**Consultation Response from KC,
Highways Development Management**
2021/91035 66, Blacker Road, Birkby, Huddersfield, HD1 5HS
Alterations to existing dwelling and erection of front and rear dormers to form 4 flats and erection of bike shed (within a Conservation Area)
Date Responded:19/05/21 Responding Officer: CNB Responding Ref:K5-5NE/28

PROPOSED REAR ELEVATION

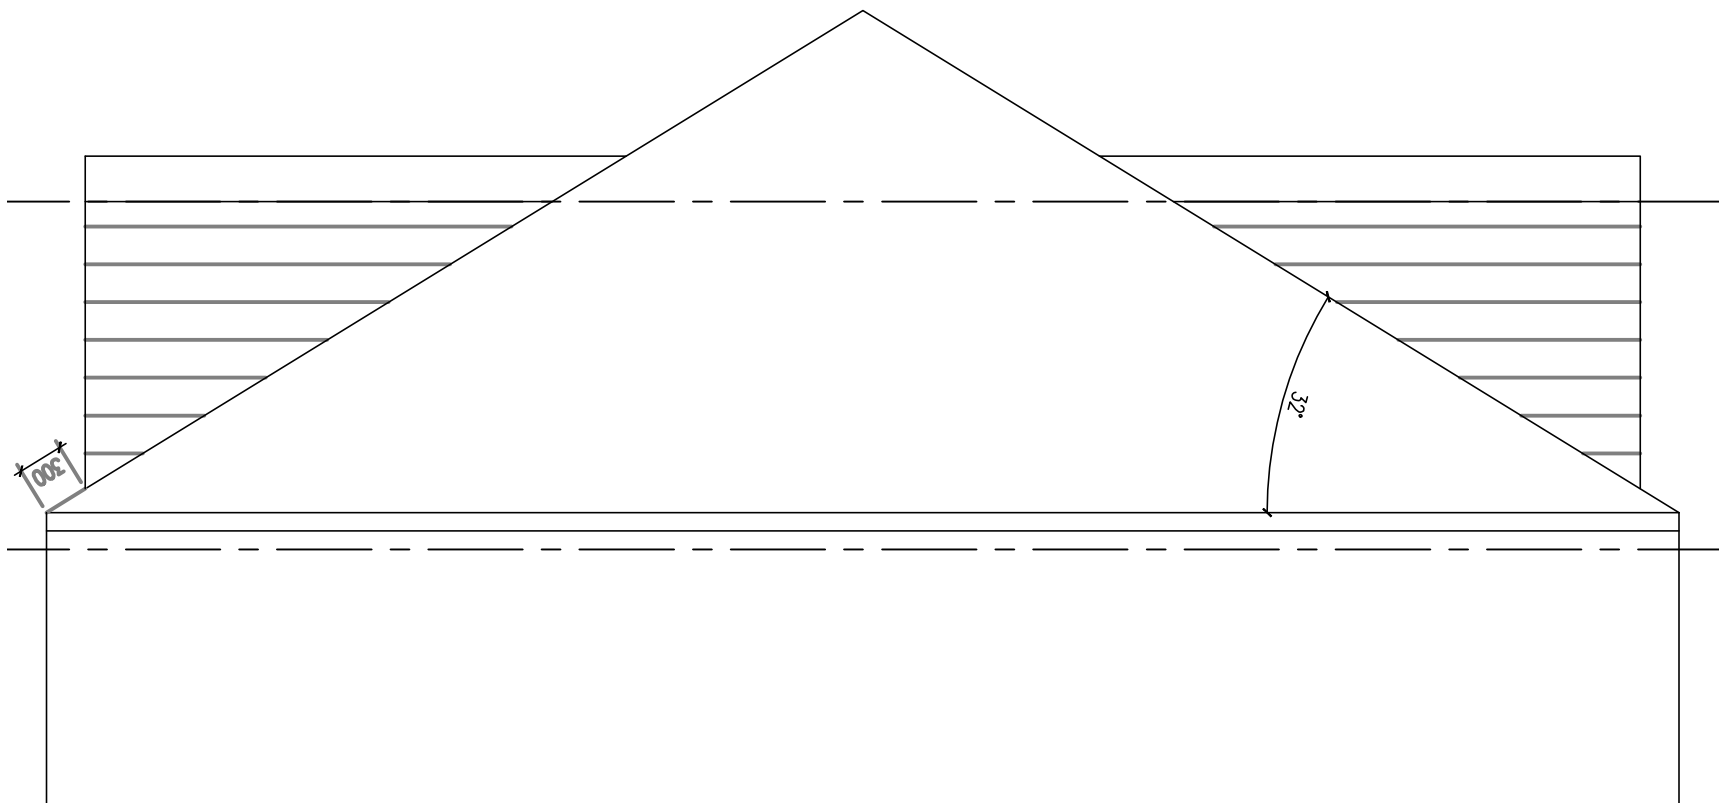
The application contains a proposal for a cycle storage shed to the rear of the property and any promotion of sustainable transport is seen as beneficial, however it should be noted that the application does not indicate that access to the rear of the property is available and so this cycle storage may not be easily usable by all the flats.
